1 No. 1-bedroom dwelling & rear extension on existing dwelling (resubmission following M/99/18/PL).

14 Baldwin Close Middleton-On-Sea

Thank you for your internet representation made on 25th April 2019 which has been recorded as **'an objection'** with the comments as follows:

AR-129-03/A

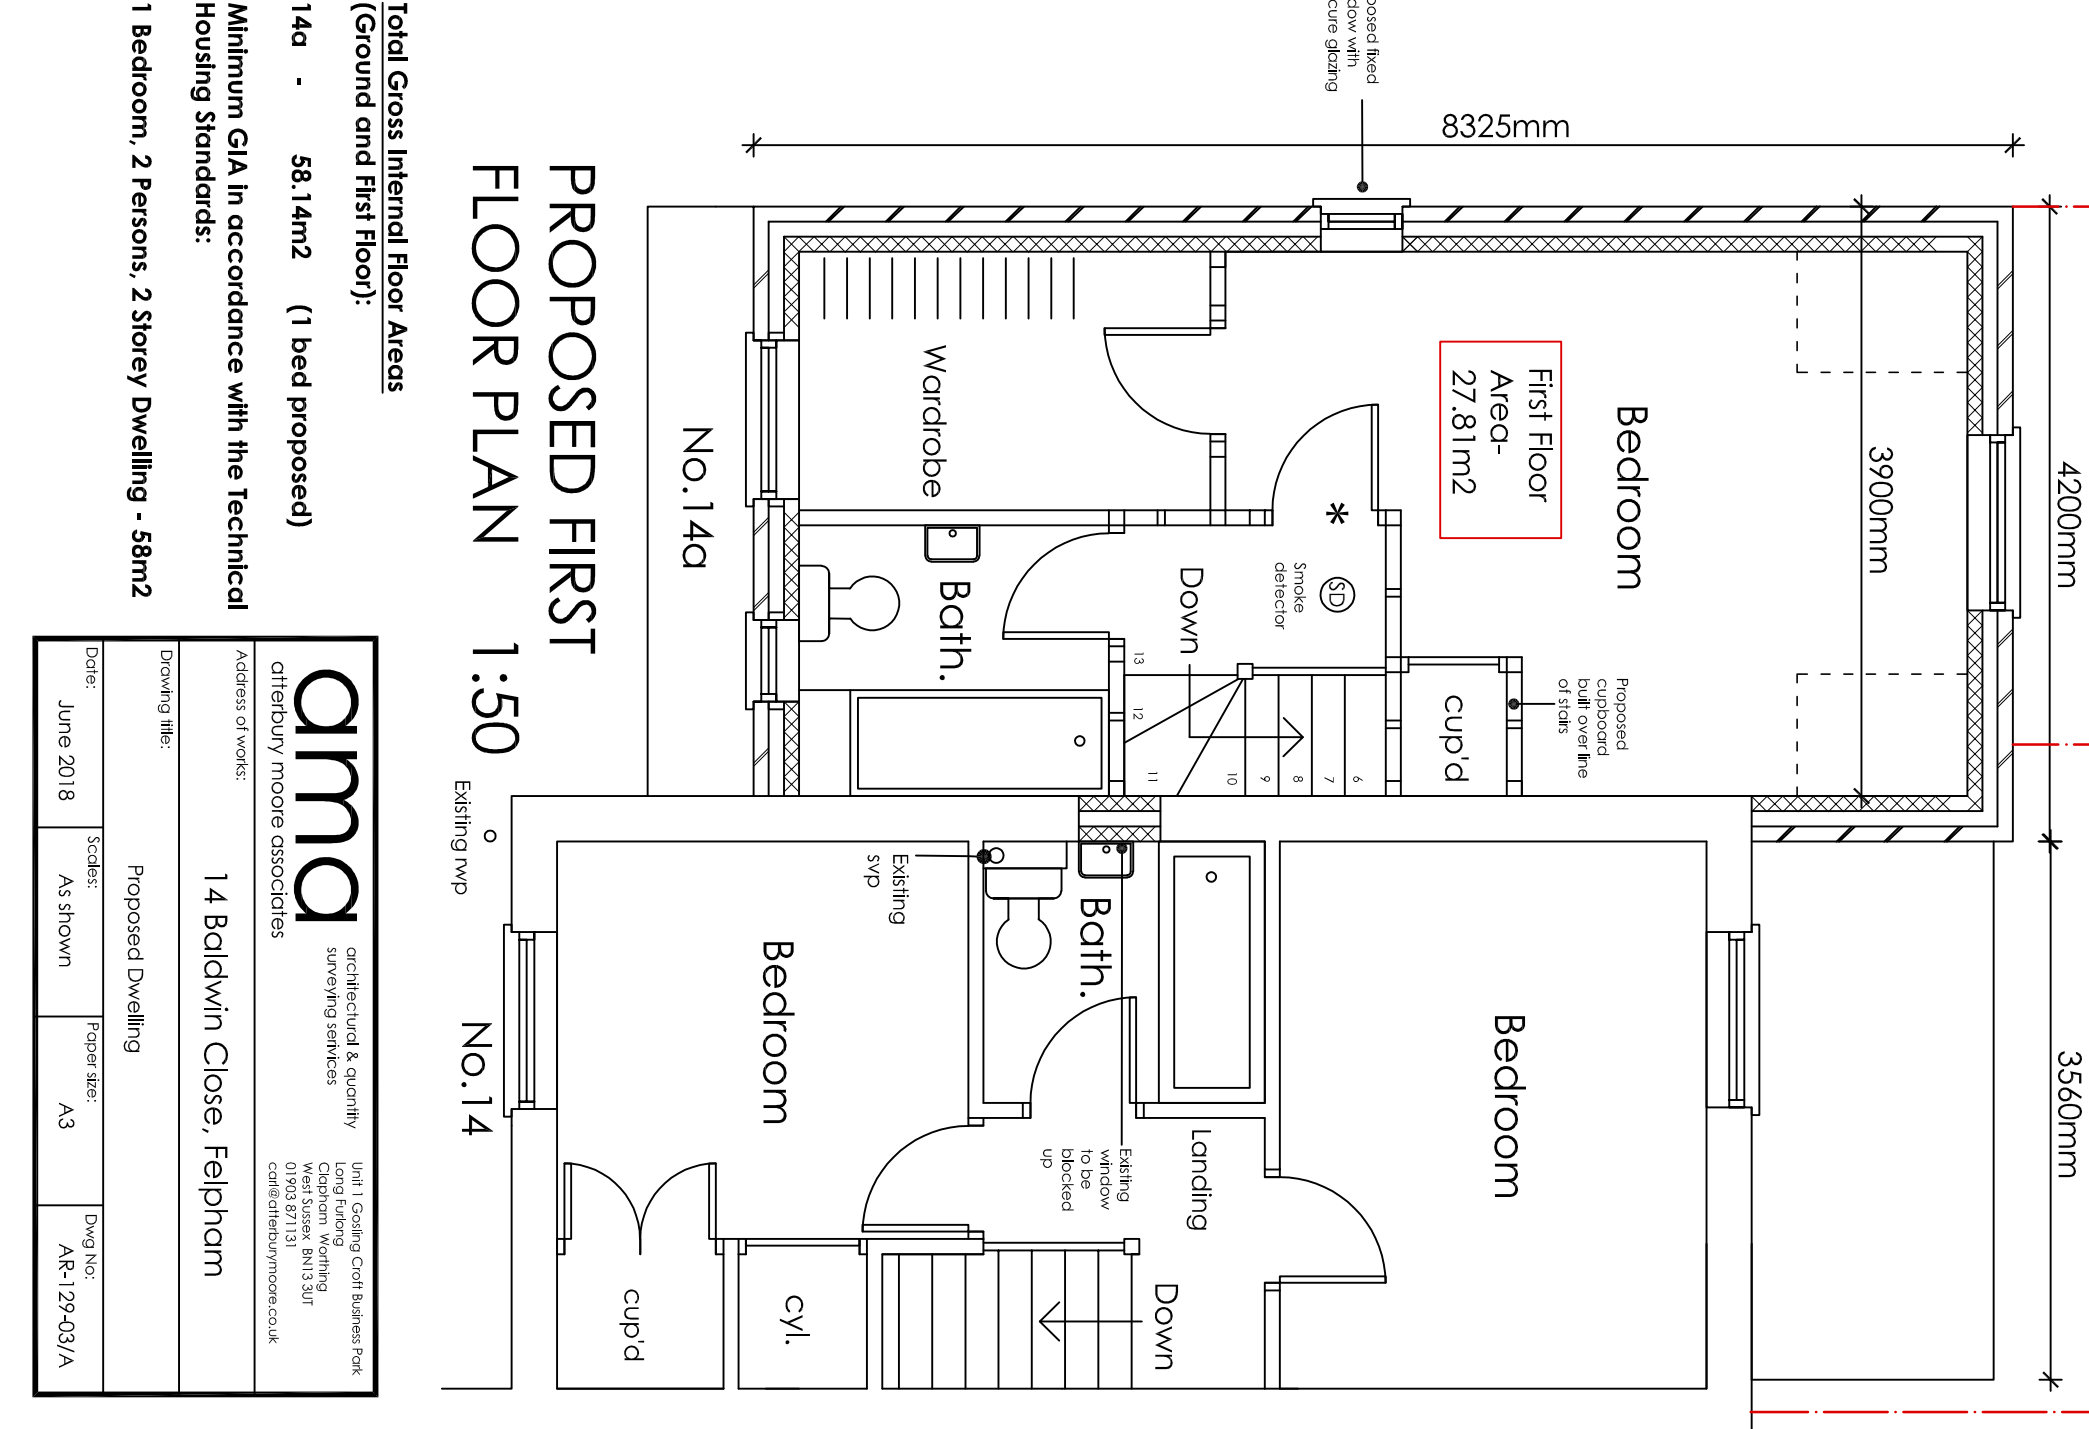
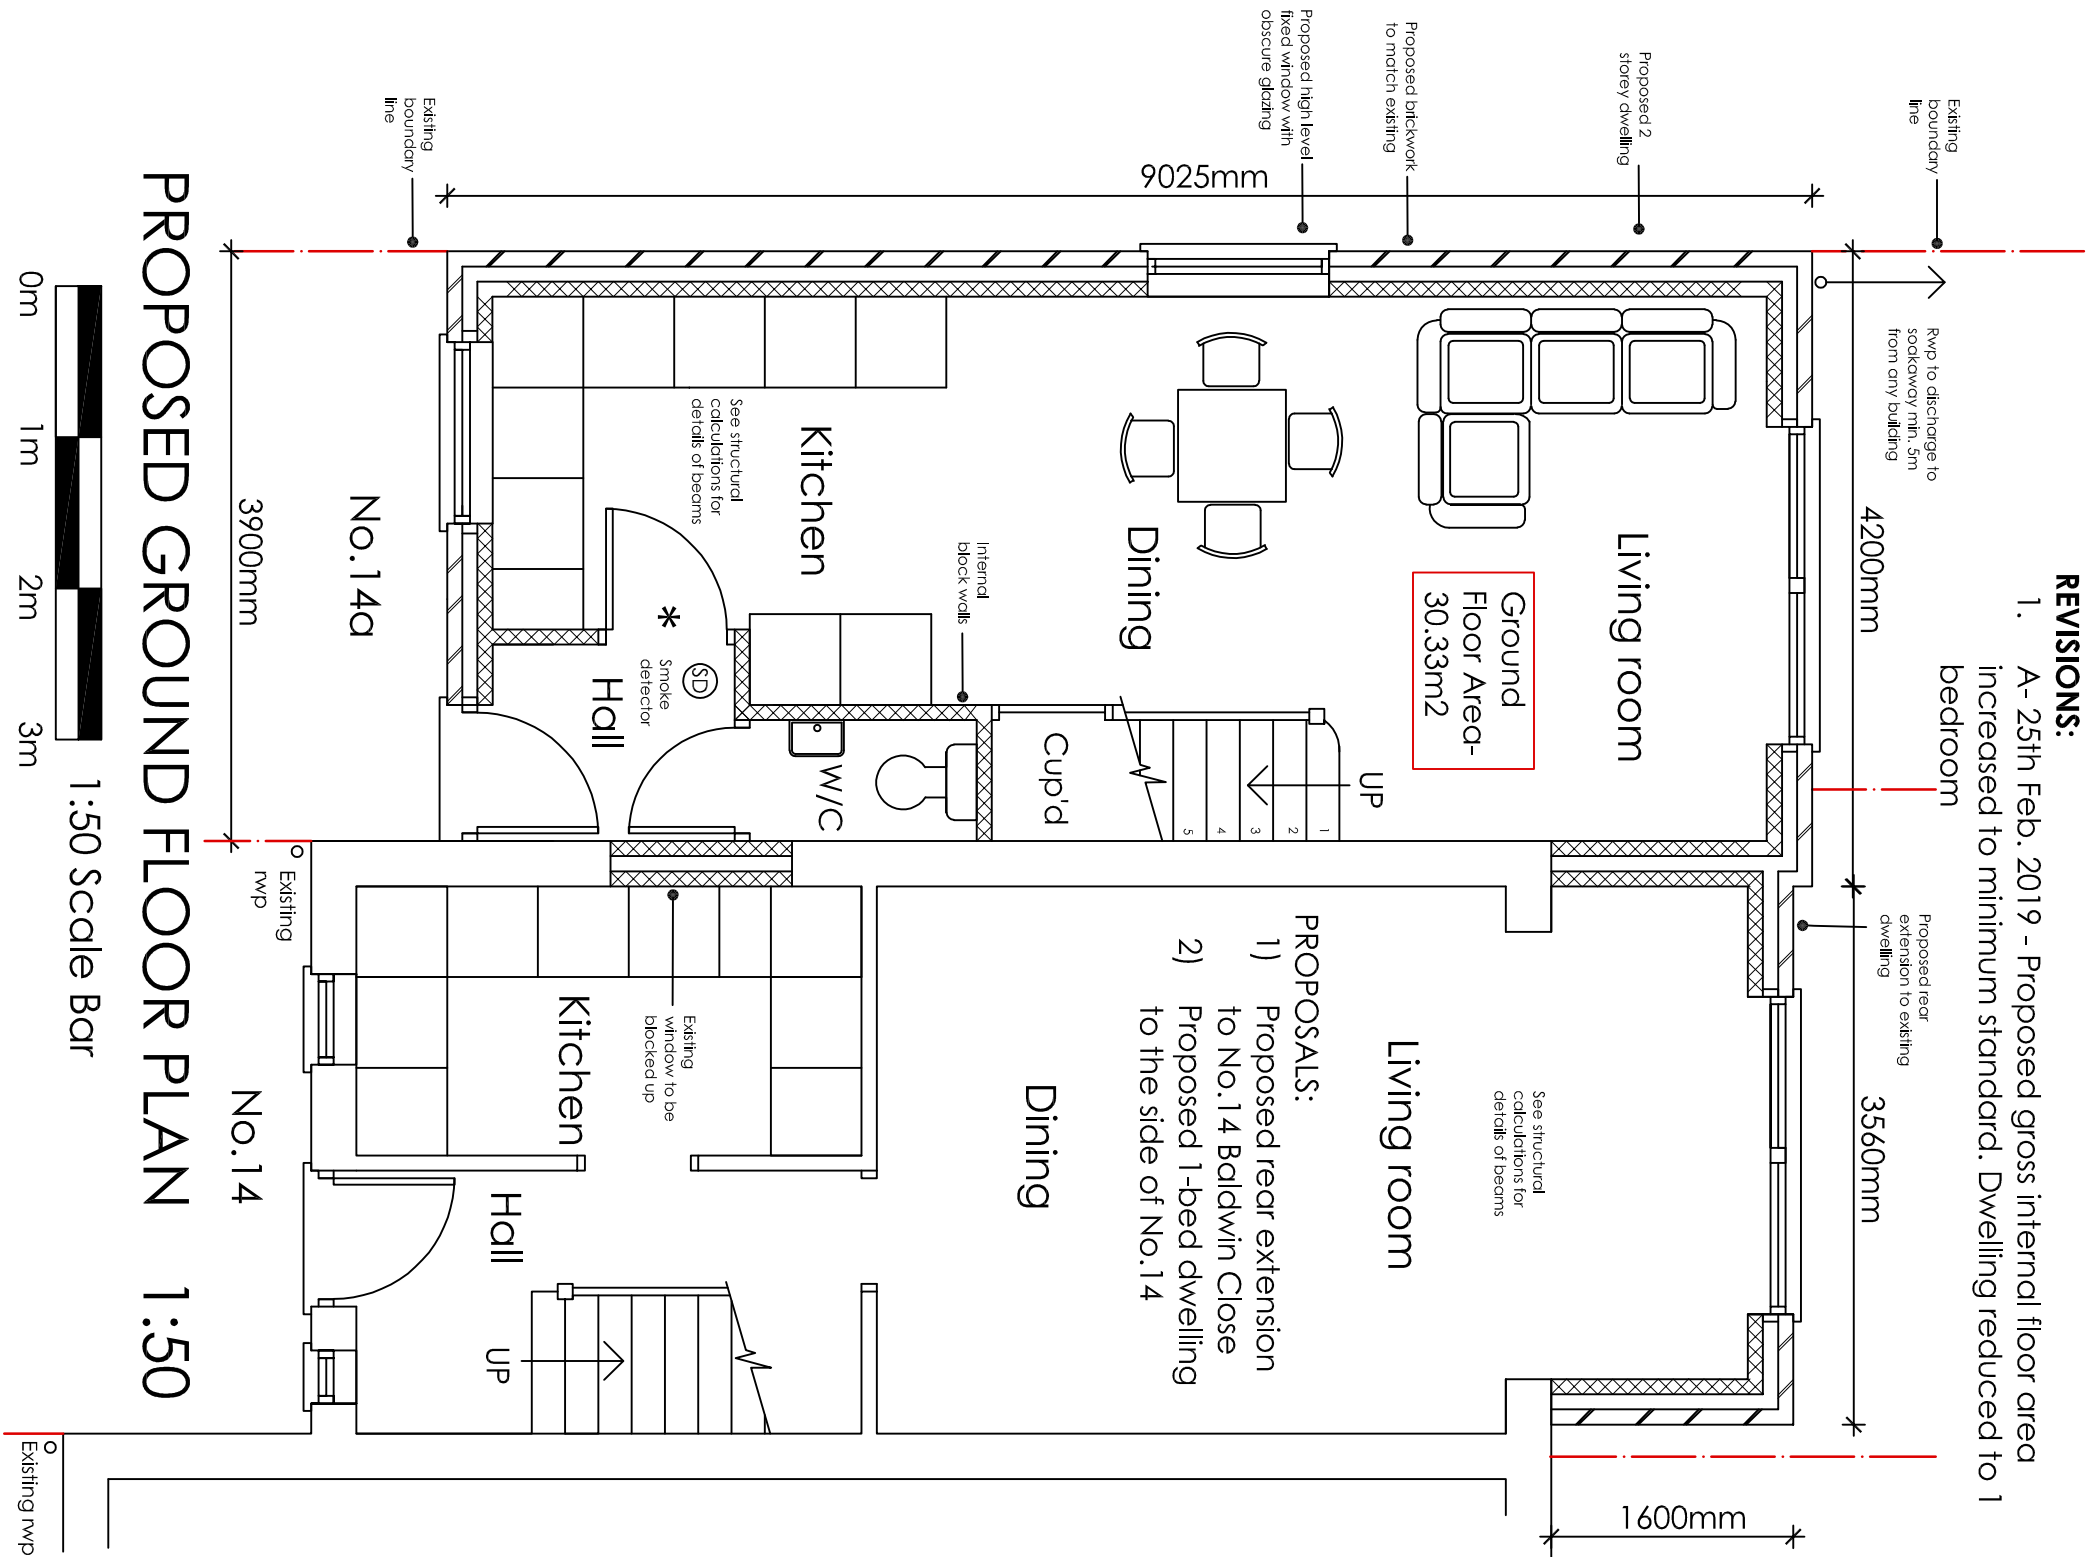
I cannot understand how this amended proposal differs from the first; the change in the floorplan of 14a to a "one" bedroom property makes a mockery of the system; if it is allowed, and signed off, a stud wall could easily be erected between the bedroom and the "wardrobe" instantly making it into a two bedroom house!
